RESPONSE TO SUBMISSIONS REPORT

Abel Tasman Village Seniors Housing

SSD-49937206

Concept & Detailed State Significant Development Application
222 Waldron Road & 138-140 Campbell Hill Road
Chester Hill, NSW

Date	March 2022	Job No.	: Drawing
Scale	1 : 100 @ A1		
Drawn	RS		2108/A1DA21
Amendment	E

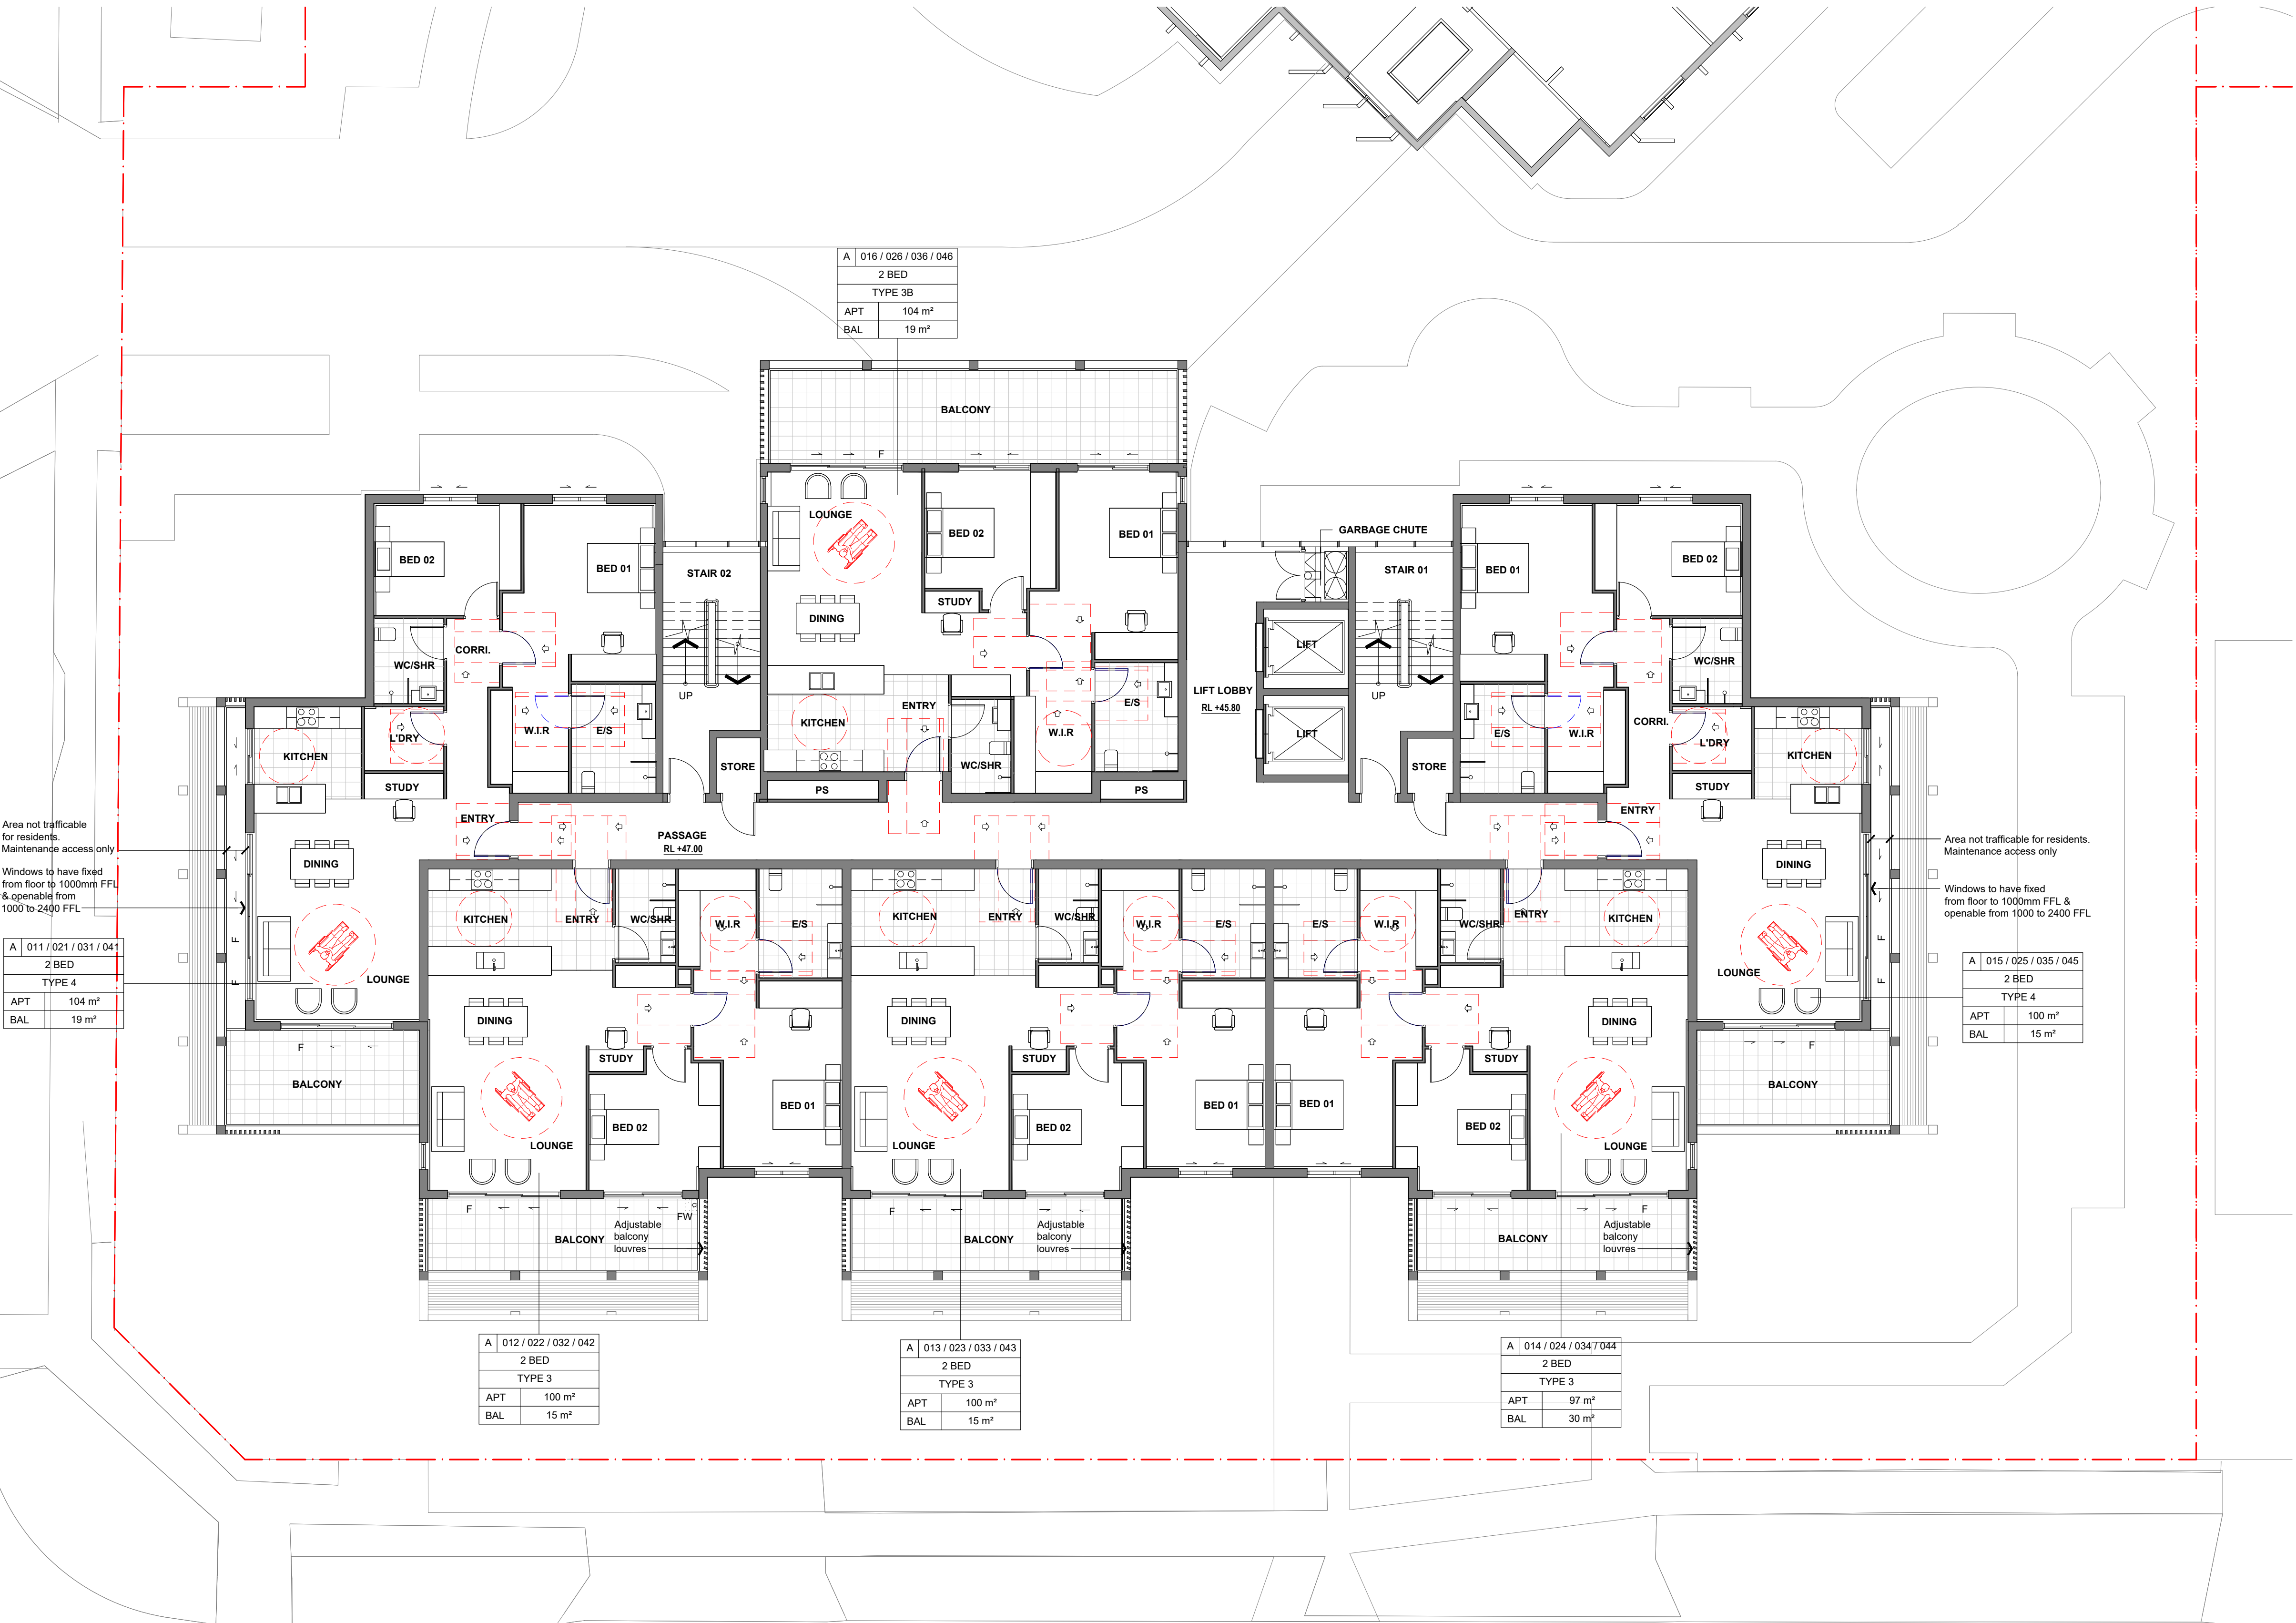
(1) Bulk and Scale – Buildings A and E	- Reduce the bulk and scale of Buildings A and E at the interface with the R3 zone; - Overlooking from Building A to north

- Full height, north-facing, glazed doors replaced with fixed window up to 1m, stopping access to the balcony in front. Access from the main balcony is restricted physically by a fence between the balustrade and the building.

- Balconies - Units 12-14, 22-24, 32-34, 42-44 - Fixed louvres on the northern balustrades replaced with adjustable louvres.

Date	March 2022	Job No.	: Drawing
Scale	1 : 100 @ A1		
Drawn	RS		2108/A1DA44b
Amendment	A

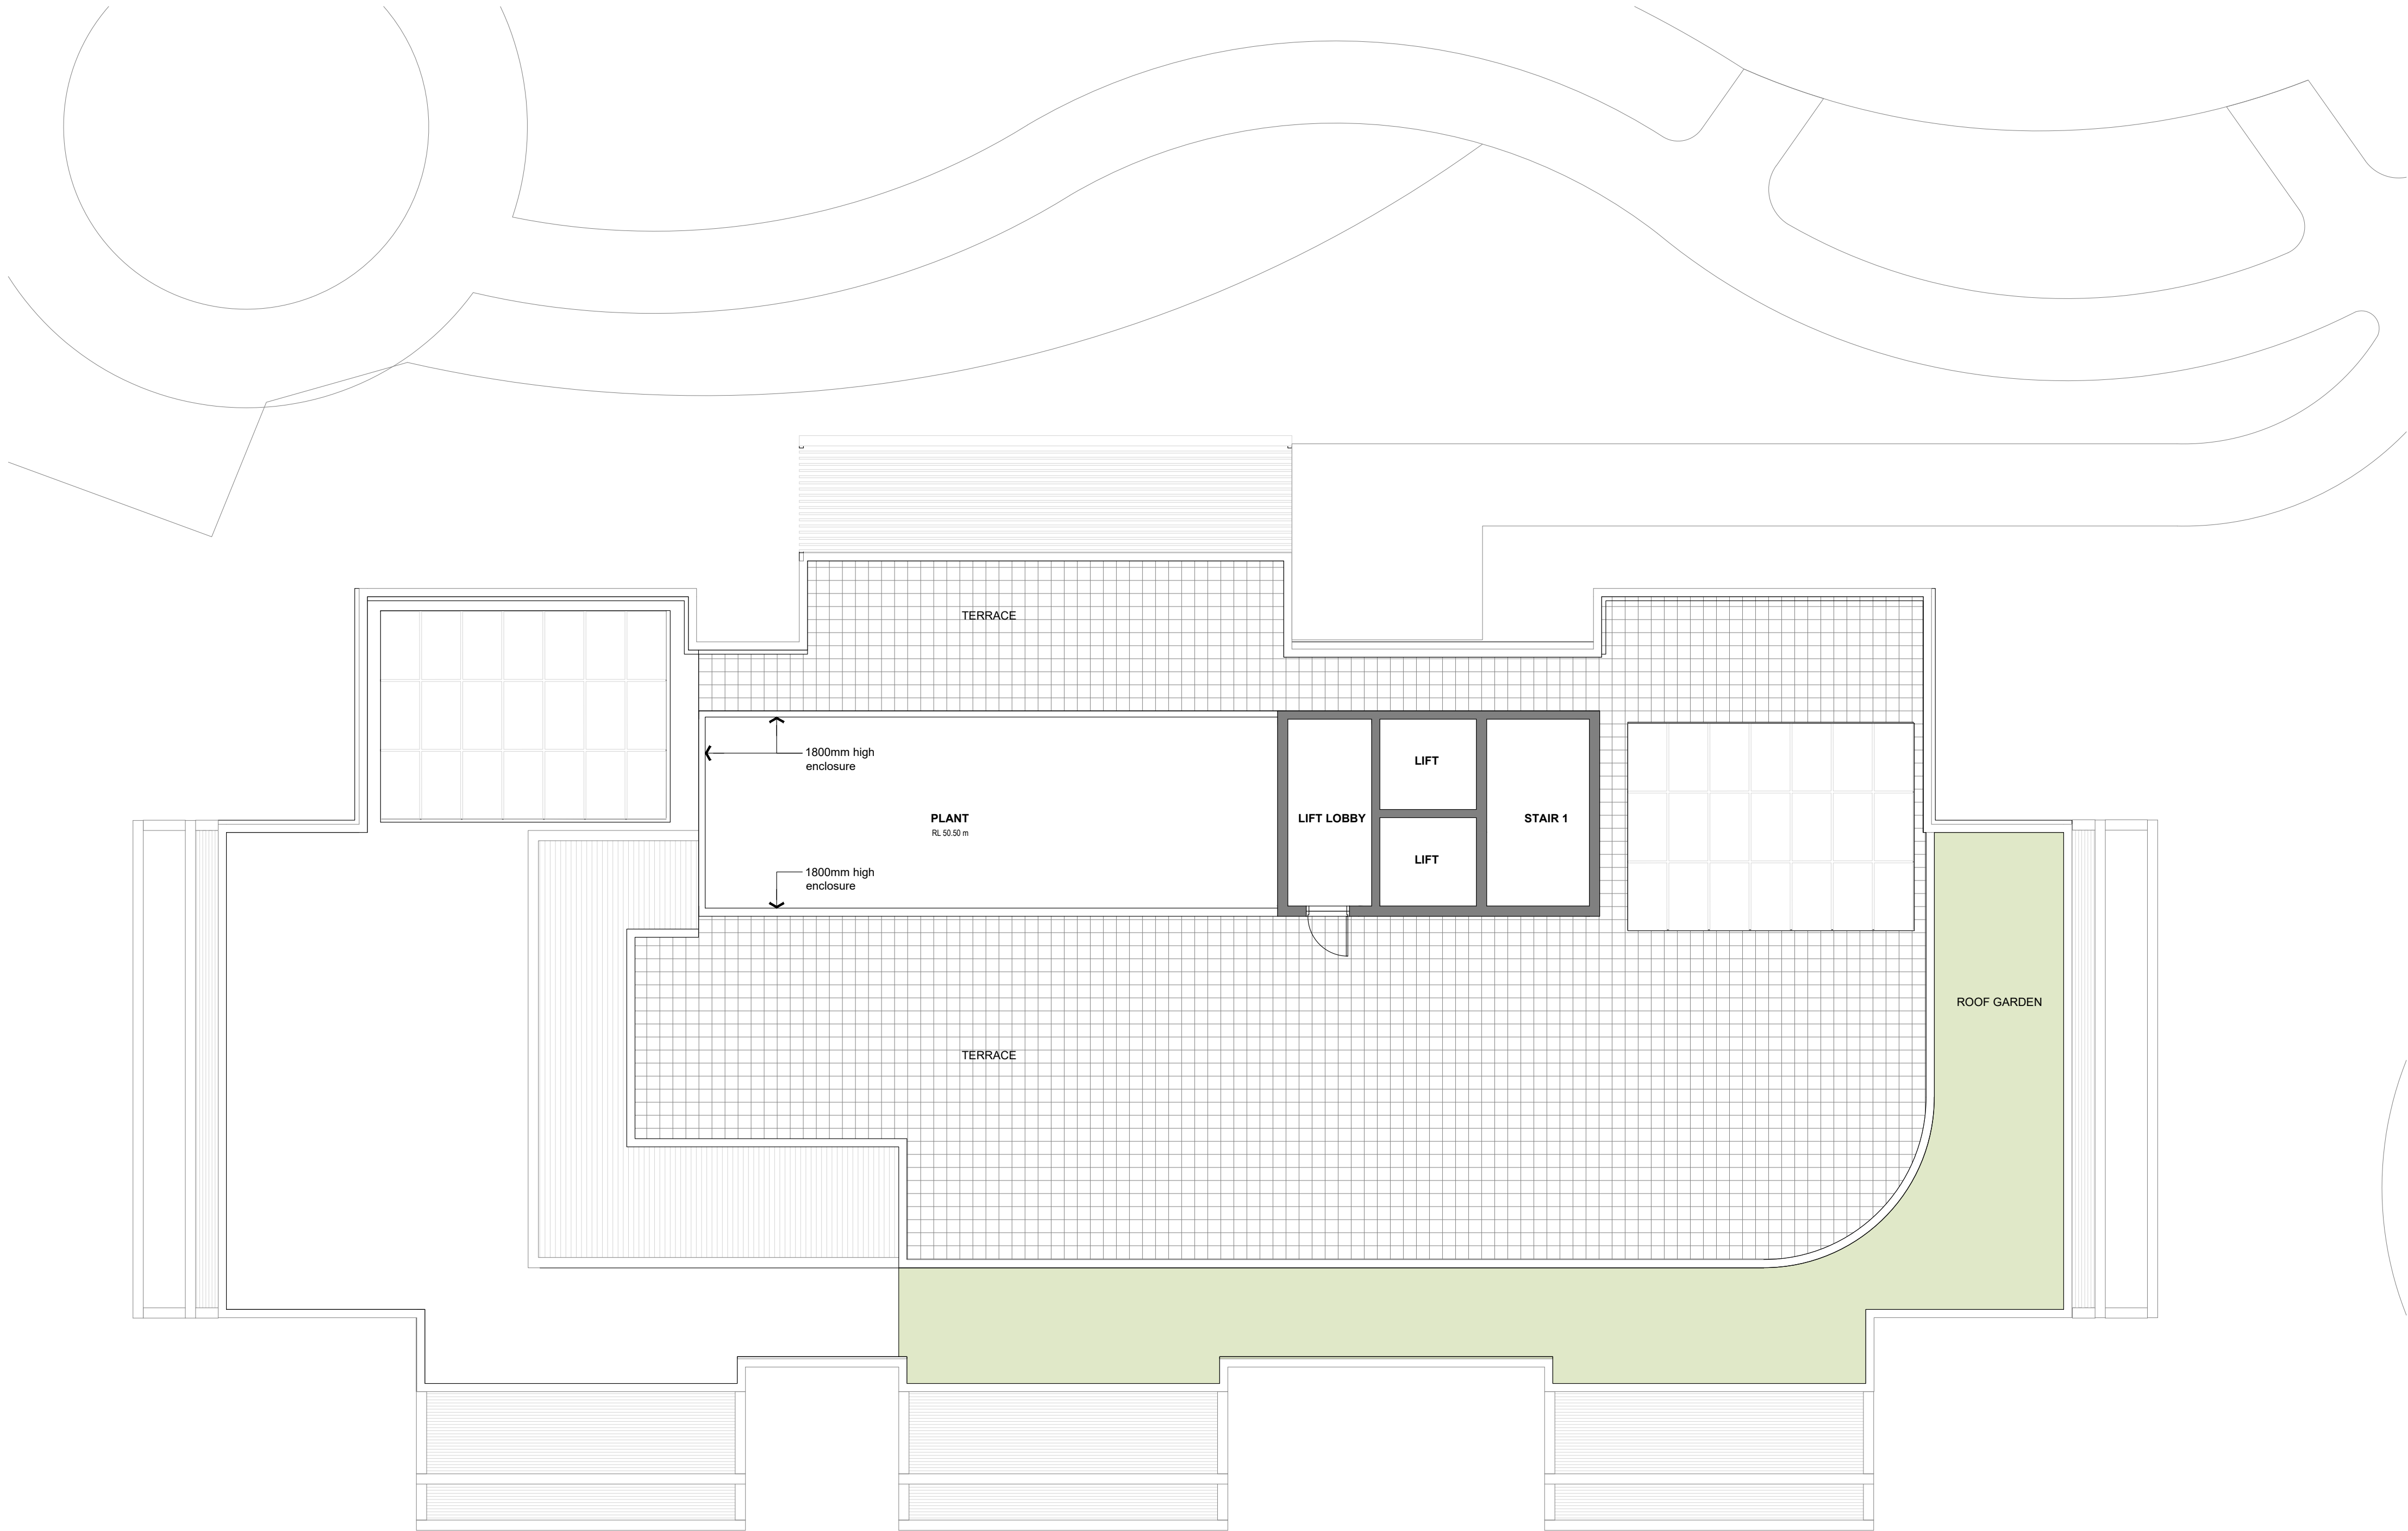
1 bedroom plus study units - Despite the nett addition of two units in Building E, the revised building will contain the same number of bedrooms. This has been achieved by converting 3 of the 2 bedroom units into large single bedroom units with an open plan area nominated as a ‘study’, which could equally be used as a hobby area or second lounge, for example. There are no enclosing walls to these spaces and they would not be suited to bedrooms.

- Balconies - Units 12-14 and 16 - Fixed louvres on the northern balustrades replaced with adjustable louvres;
- Unit 11 northern balcony edge treated similarly to modified balconies at Levels 2-5 in Building A. Refer to Figure 1 above.
- Unit 13 converted to “1 bedroom plus study” unit.
